RE: Letter of Intent

Aspen Sign & Lighting is requesting special use permit authorization for a contractor's equipment yard on 3 parcels adjacent to our sign business. We are proposing to use lot 1 as storage for pipe and steel. We are proposing lot 2 to be used as truck parking and taller sign storage. By moving the tall signs and trucks more than 25' back from the property line, we are making sure these items will not be visible to the neighbors. We are proposing lot 11 to be used as sign storage for signs less than 6' in height. To reduce visibility to the neighbors, we are installing a 6' tall chain link fence with a privacy screen around the perimeter of lots 1, 2 and 11.

PLOT PLAN / SPECIAL USE DRAWING

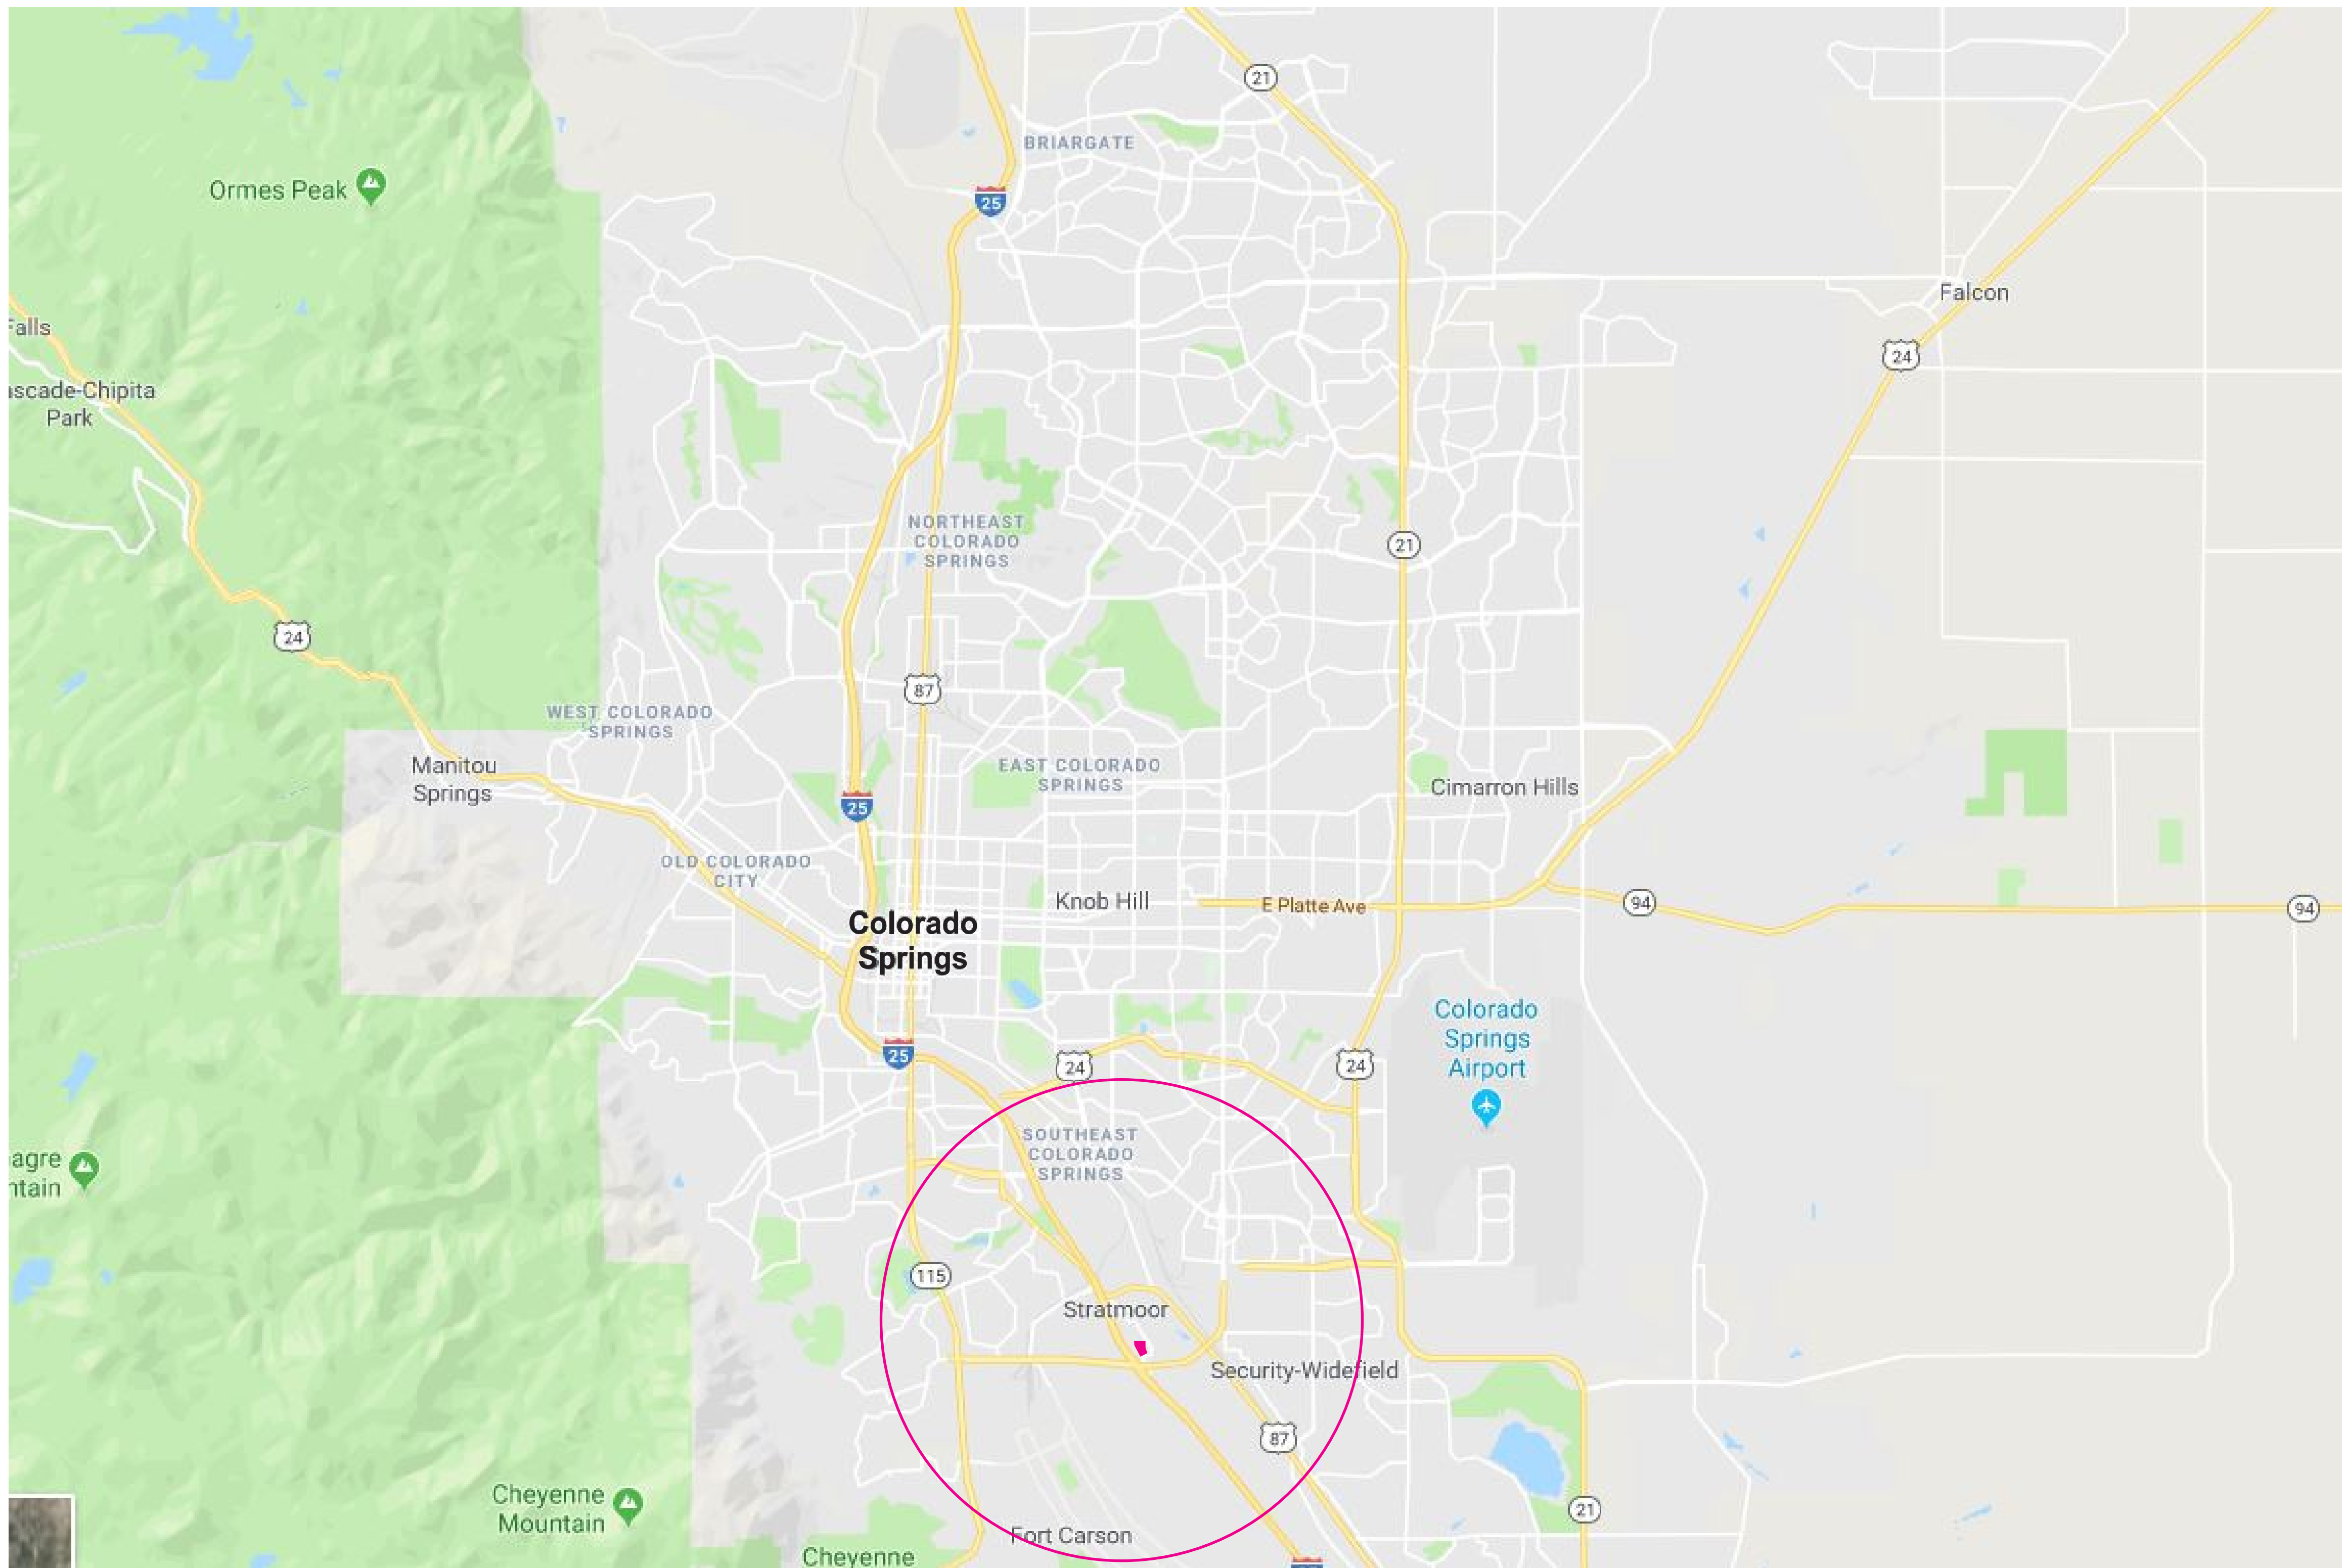
This landscaping would require a work in the right-of-way permit and will the landscaping requirements of Chapter 6 of the Land Development Code will be reviewed in the Site Development Plan Process.
